ITEM 1.6

**Issue/ Objection:**  
Apartment Size and Layout

**85 Harrington Street  
The Rocks  
GOLDEN AGE & HANNAS THE ROCKS**

**RESPONSE TO DoPE  
ITEM 1.6**

**2** ELEVATION 201-312 Window Elevations  
1:50

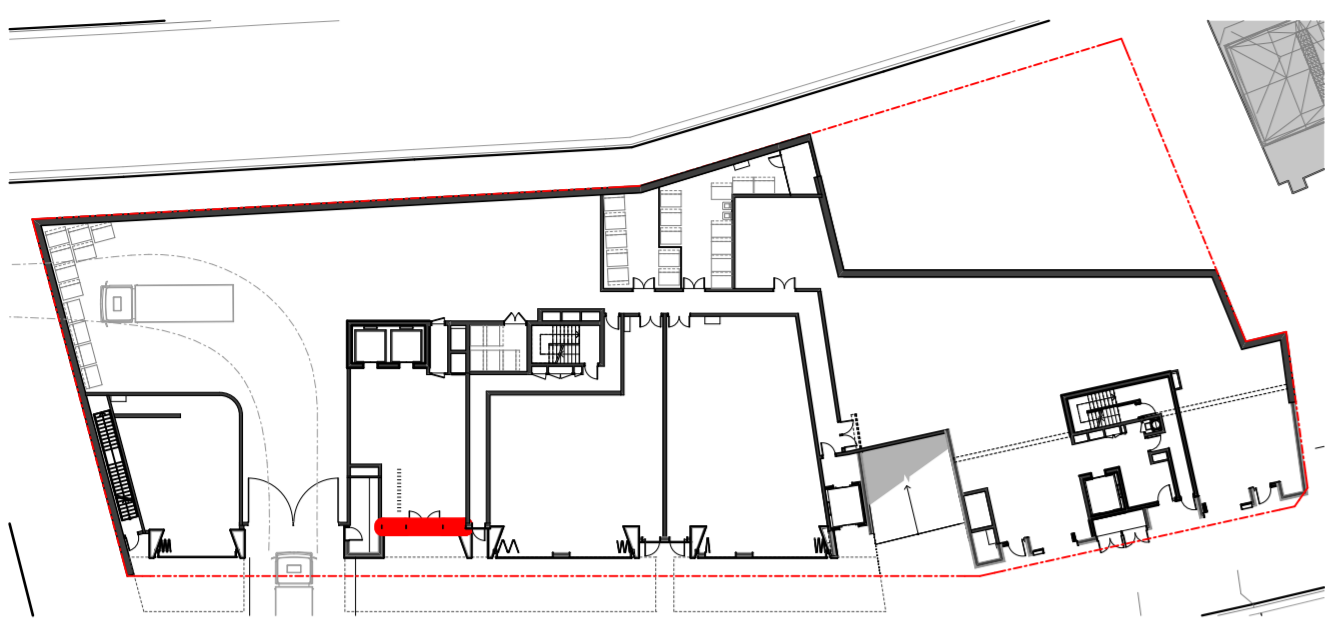
**Description:**  
In addition, confirm that windows serving north facing bedrooms in units 201 and 312 in Building 1 achieve a total minimum glass area of not less than 10% of the floor area of the room

**Response**  
Compliance is met with the windows servicing both 201 and 312 (Building 1) exceeding a glass area of not less than 10% of the floor area of the room.
